Recommendation Report for Planning Permission for Works or Extension to a Dwelling

REF NO: BE/8/26/HH

LOCATION: 70 Central Avenue
North Bersted
Bognor Regis
PO21 5HW

PROPOSAL: Loft conversion with hip to gable end and rear box dormer extension.

Drawing: PL02

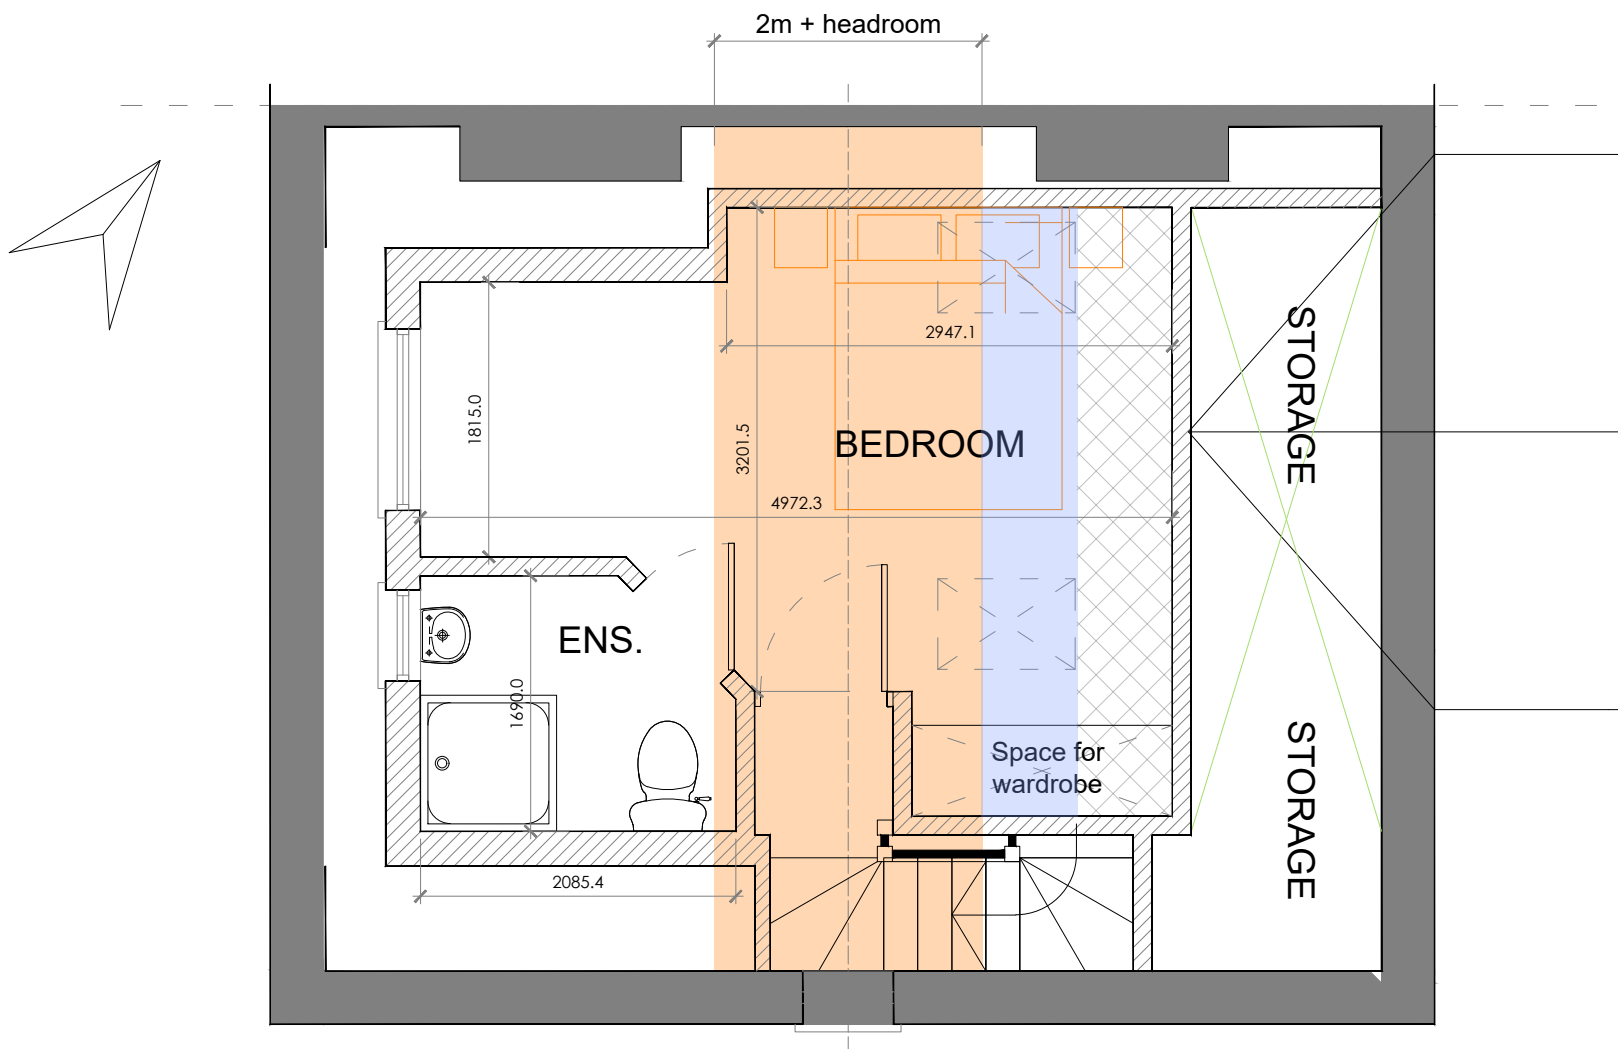
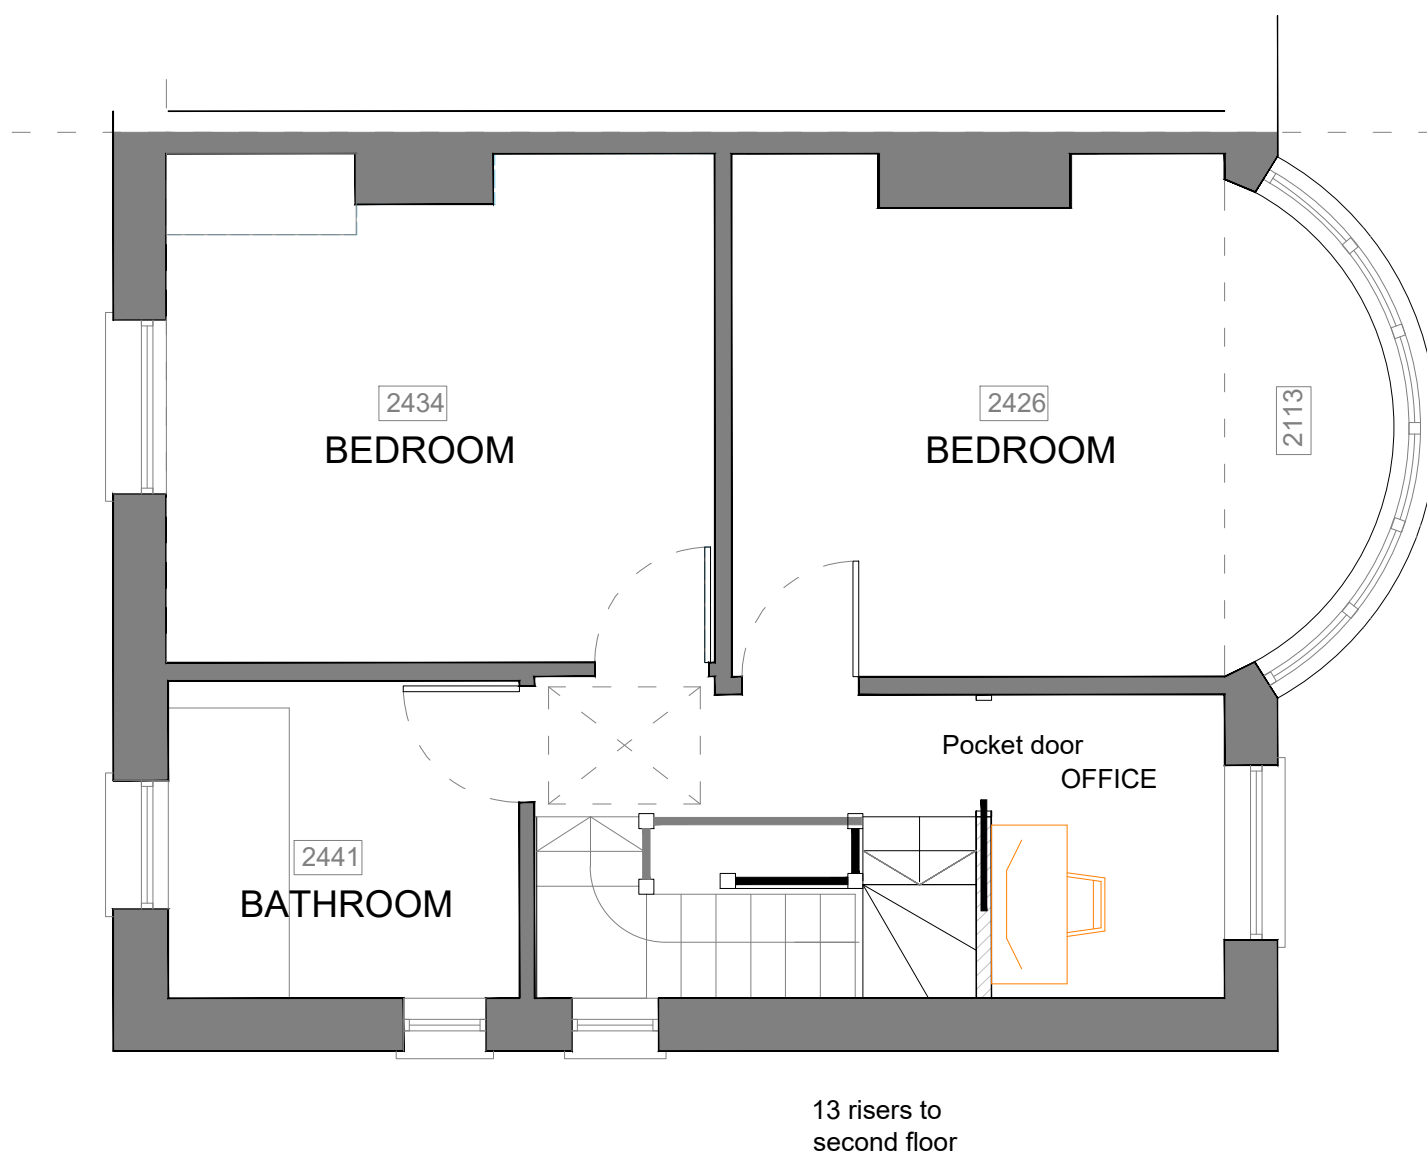
The proposed rear dormer would measure 2.6m in depth, 4.1m in width, and 2m in height, and would be constructed with a flat roof. The dormer is in partial conflict with the Arun Design Guide (ADG), which states that dormers should be minor incidents on the roof plane and incorporate pitched roofs in most cases, avoiding large box shaped designs. Although the dormer does not strictly comply with the guidance set out in Part M of the ADG, the dormer would be sited to the rear, it would be set down from the ridge by 0.4m and set in from the flank elevations by at least 0.8m of the host dwelling and set up from the eaves by 0.7m. As such, whilst the dormer is a large addition to the rear roof slope, the rear roof slope would remain discernible, and the proposal would not result in demonstrable harm to visual amenity.

One second floor side window is proposed, which would serve the stairwell. Given the size of this window, and its siting centrally within the gable end, the proposed window would not result in unacceptable overlooking. As such, it would not be reasonable to condition this window to be obscurely

glazed and non-openable below 1.7m above the internal floor level. The windows within the dormer would have an outlook over the rear amenity space serving the host dwelling. Whilst some views of neighbouring gardens would be available from the proposed dormer, these views would not be significantly different to those already achieved via the first floor rear fenestration. Therefore, the proposed dormer would not result in unacceptable overlooking. The rooflights would be positioned within the front roof slope of the host dwelling and would not result in any overlooking.
